27th October 2021

Application No: AW/325/21/HH
Site Address: Blue Haze 37 The Drive Aldwick PO21 4DT
Description of works: Erection of single storey side/rear extension, front porch extension and detached garage to front
(This application may affect the character and appearance of the Craigwell House, Aldwick Conservation Area)

Thank you for your internet representation made on 26th October 2021 which has been recorded as an objection with the comments as follows:

PROPOSED GROUND FLOOR PLAN

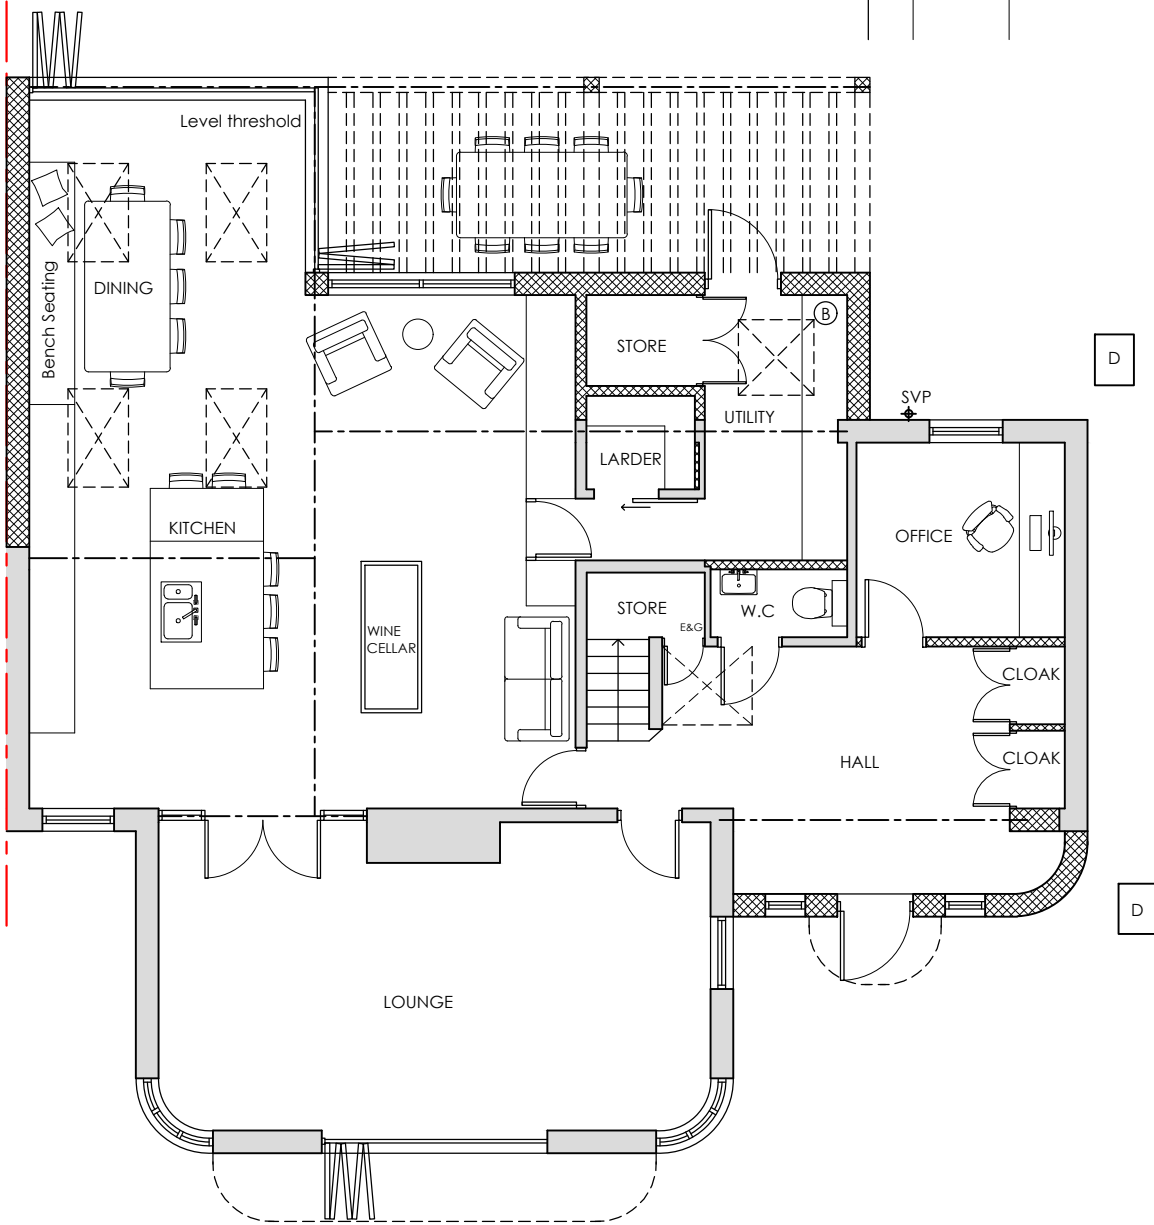
Members strongly objected to the application on the grounds that the proposed extension would have an adverse overshadowing and overbearing

effect on neighbouring properties and because it would compromise the established spatial character and pattern of the place. Members further considered that the extension does not acknowledge the character of its

special environment in layout, form scale, enclosure and the spaces between buildings and because it is not sympathetic in scale and form

to the existing building, or to the buildings in the area and it does not retain

important open spaces and other elements of the area s established pattern of development, including gardens. Furthermore, as the house is located in
